**WELWYN HATFIELD BOROUGH COUNCIL
EXECUTIVE DIRECTOR - PLANNING, PUBLIC PROTECTION AND GOVERNANCE**

Application No: 6/2020/1872/LAWP
Location: 89 Lemsford Road Hatfield AL10 0DZ
Proposal: Certificate of lawfulness for hip to gable and dormer roof extensions.
Officer: Mr Tom Gabriel

6/2020/1872/LAWP

PROPOSED EAST ELEVATION

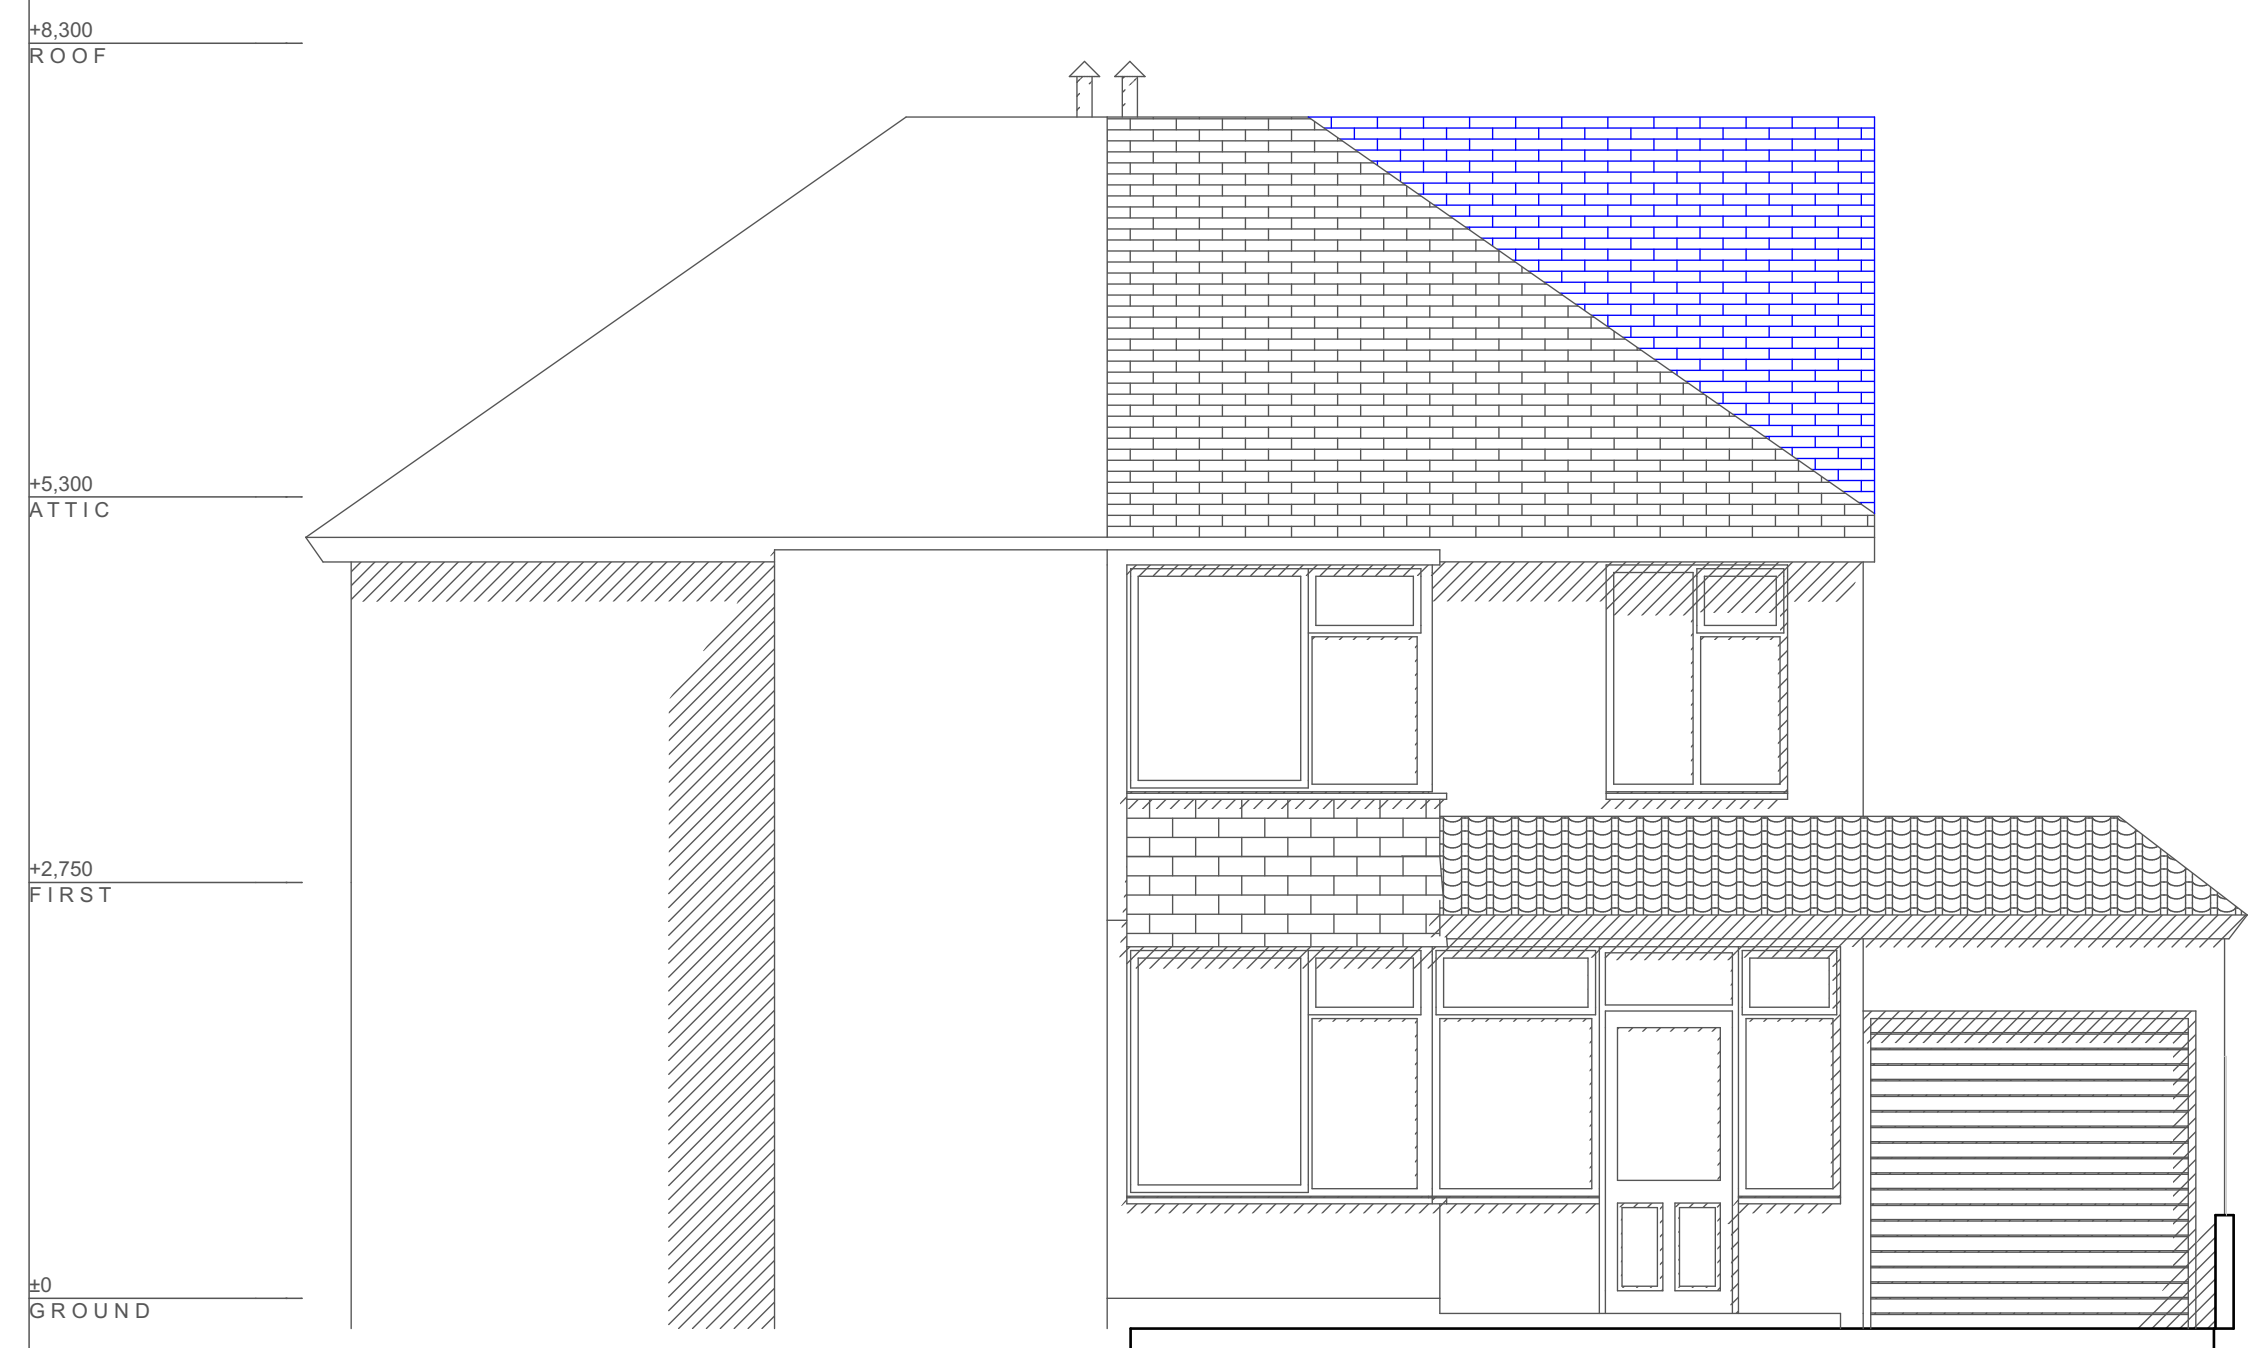
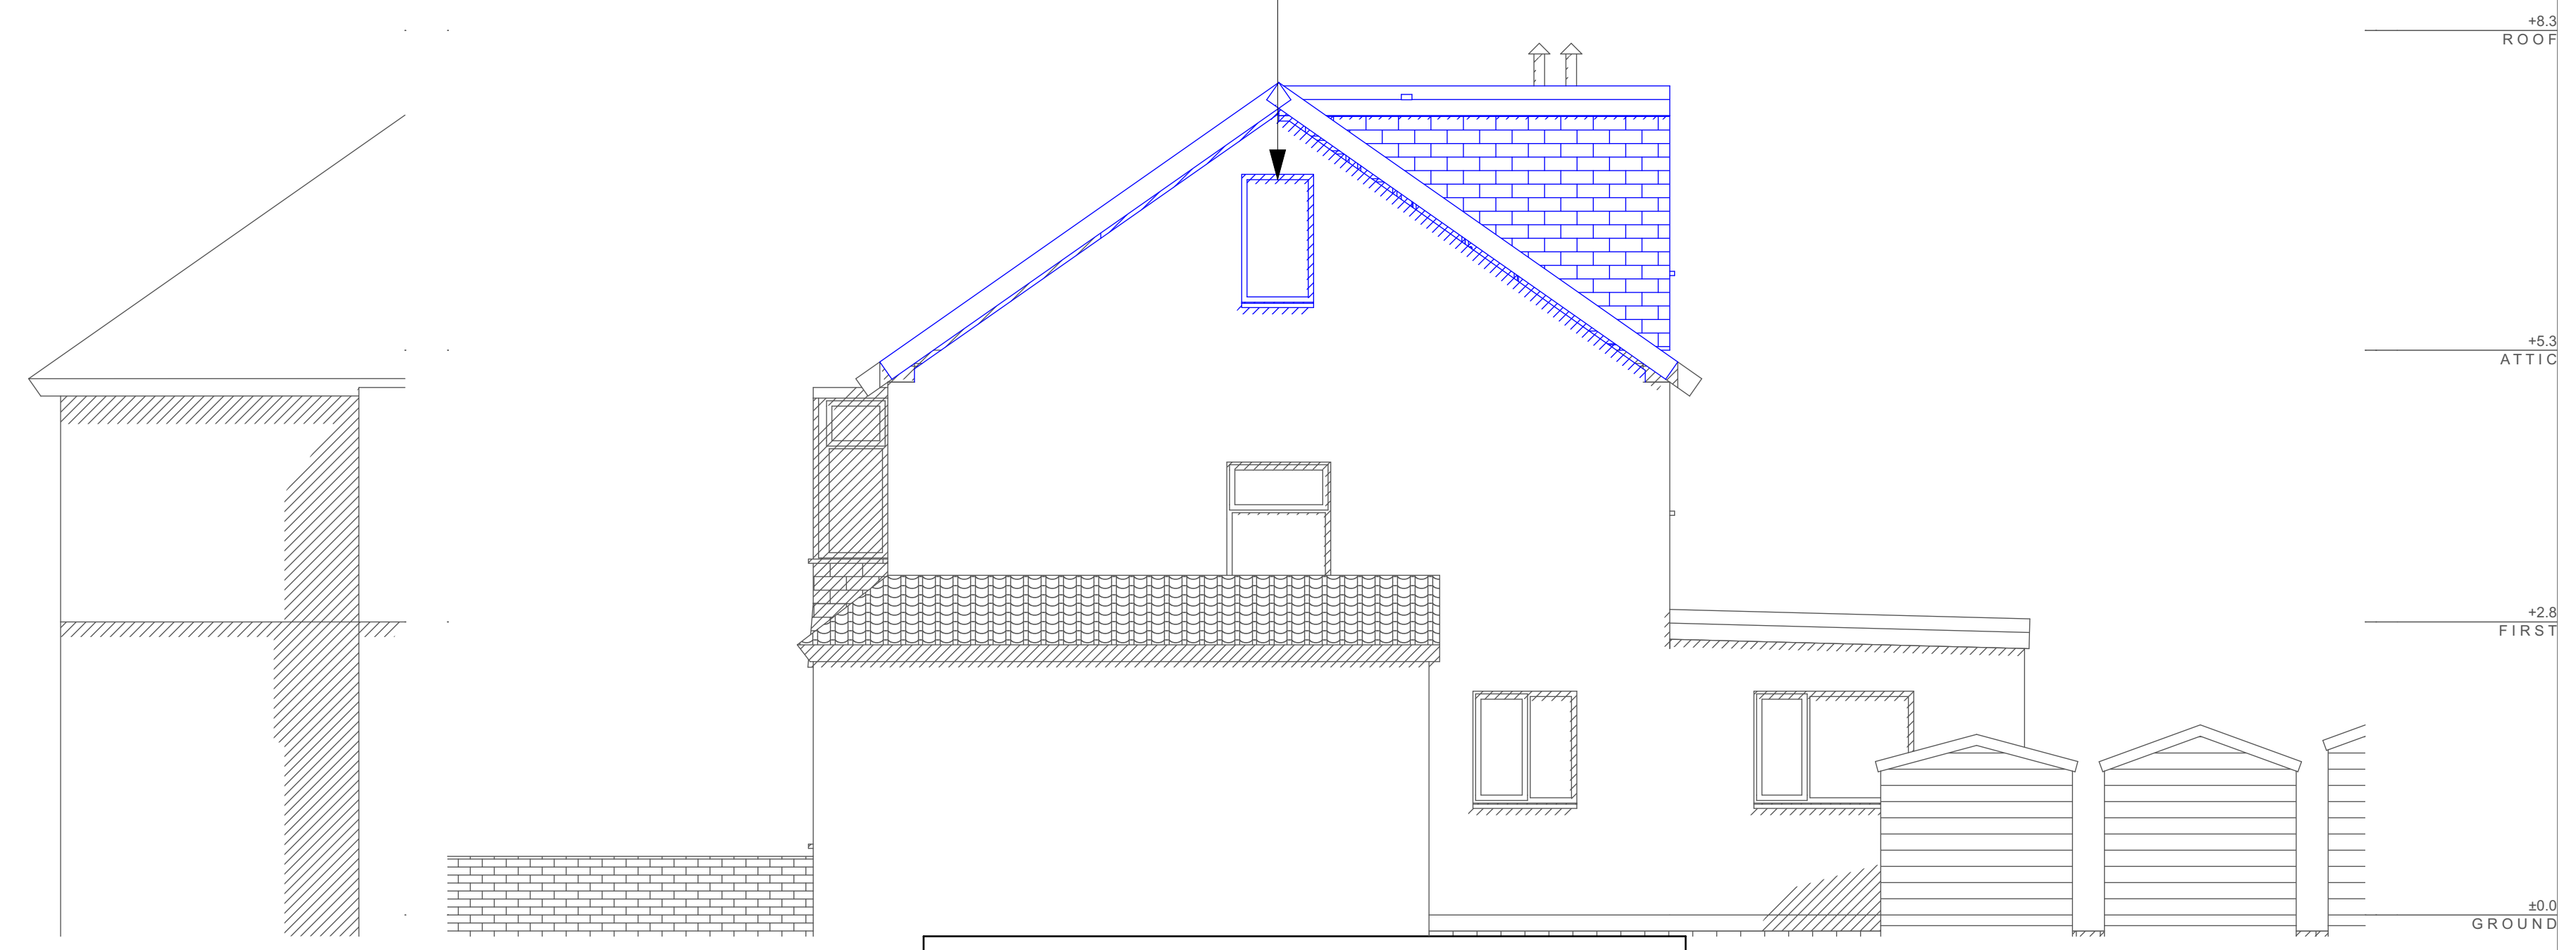
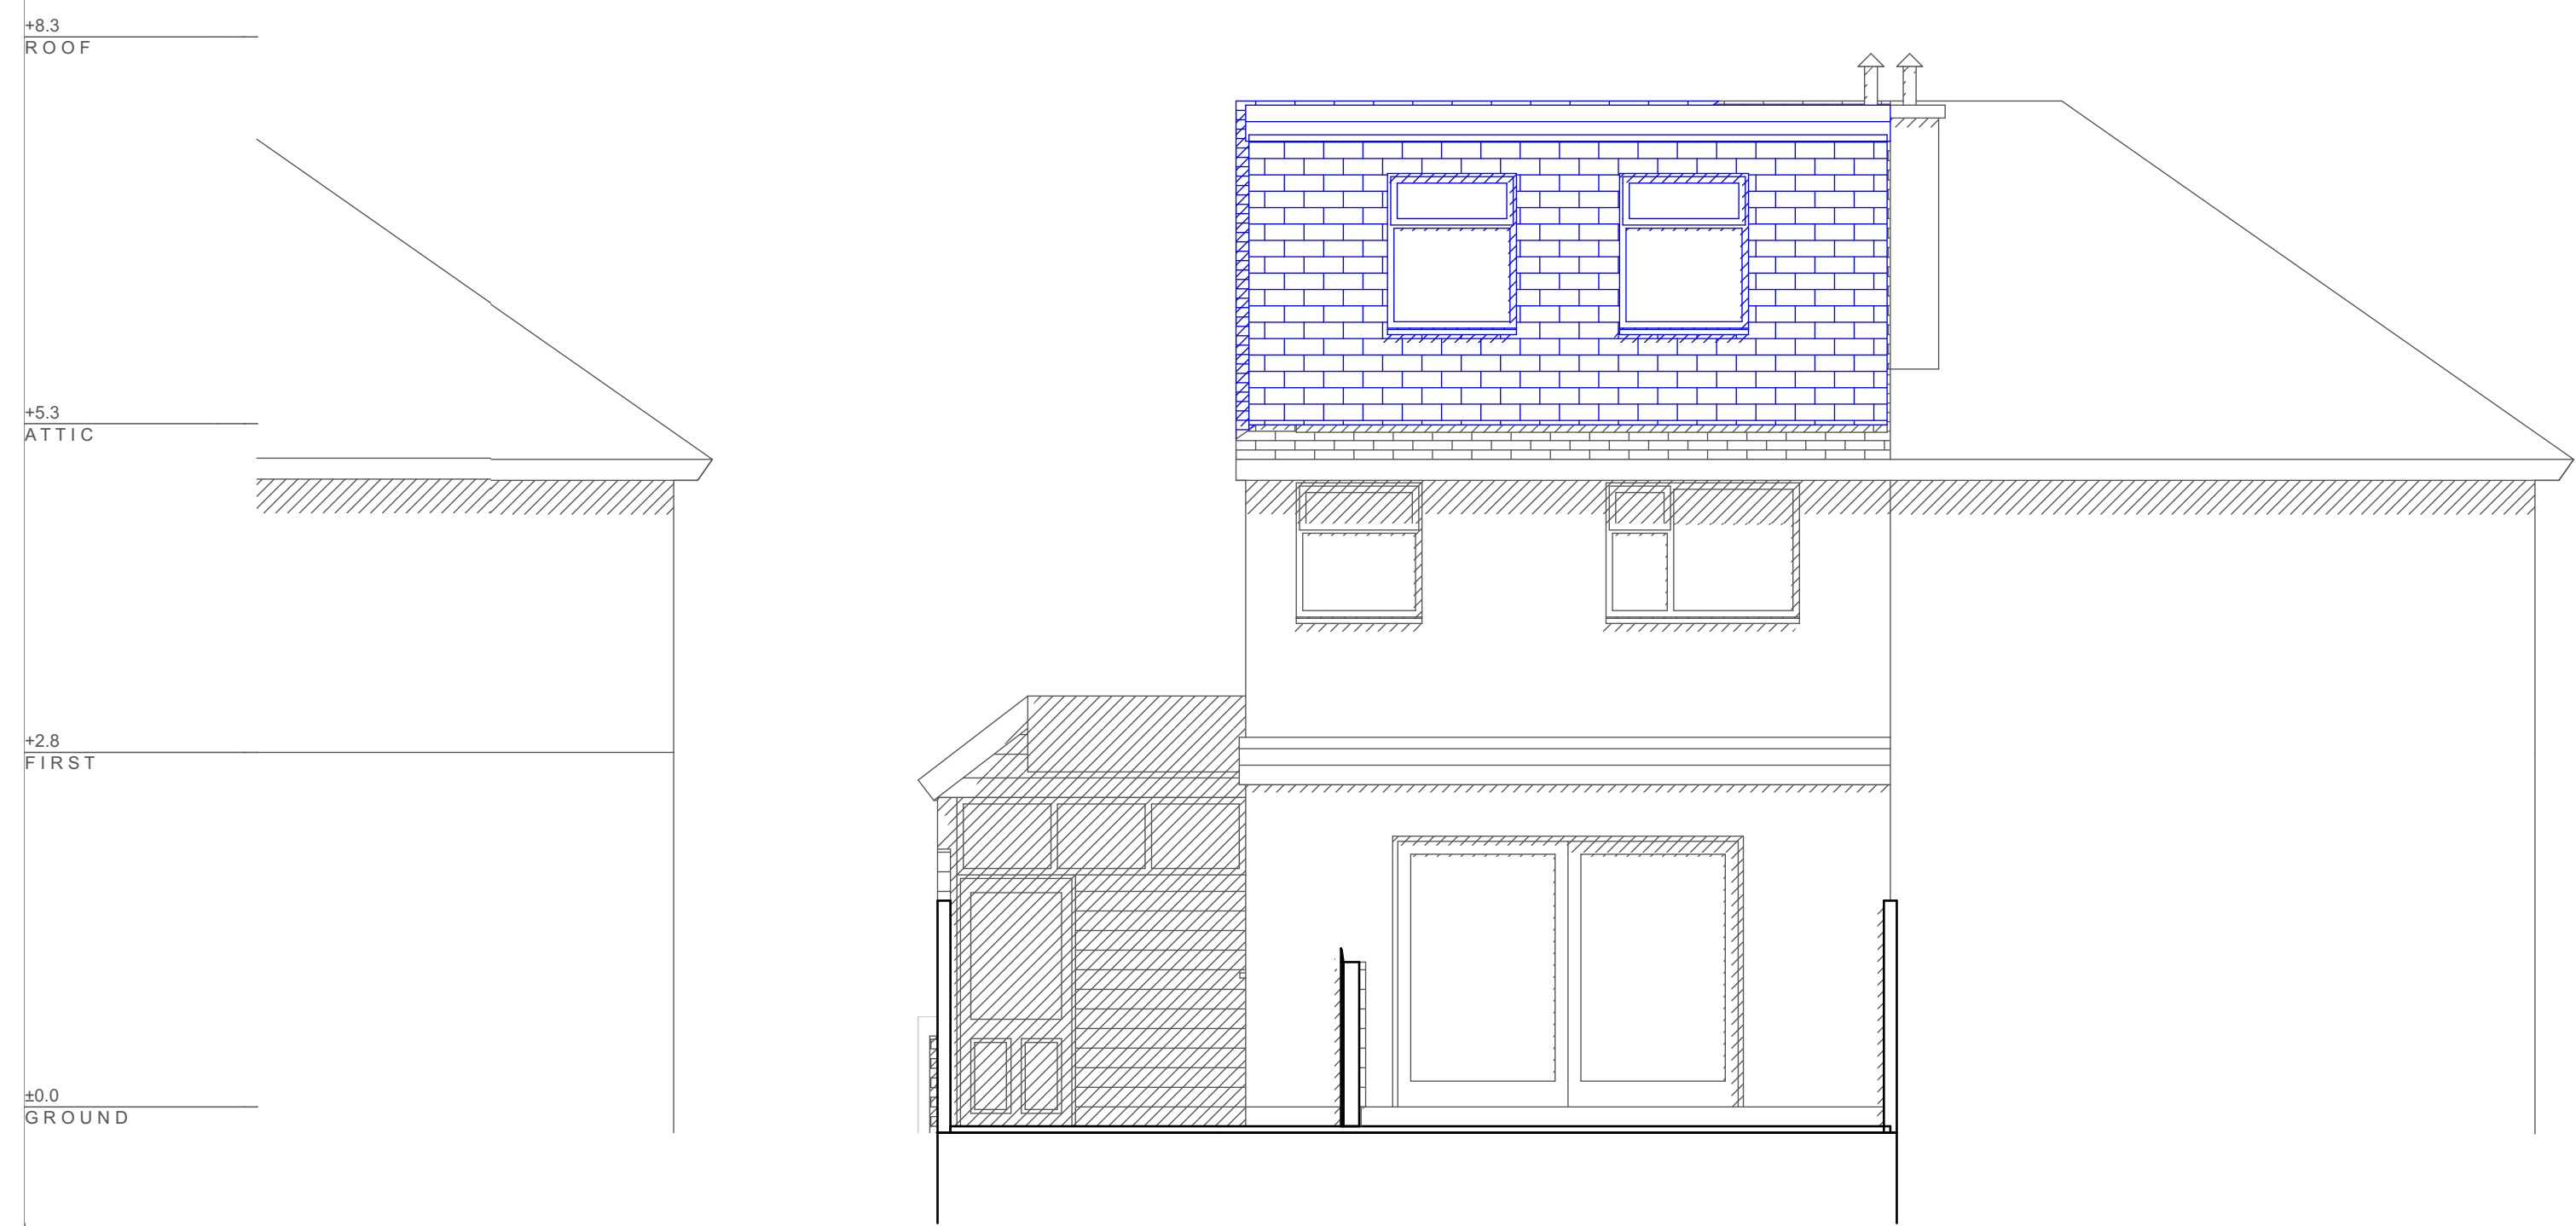
| (b) would any part of the dwellinghouse, as a result of the works, exceed the height of the highest part of the existing roof | N | N |

| (c) would any part of the dwellinghouse, as a result of the works, extend beyond the plane of any existing roof slope which forms the principal elevation of the dwellinghouse and fronts a highway | N | N |
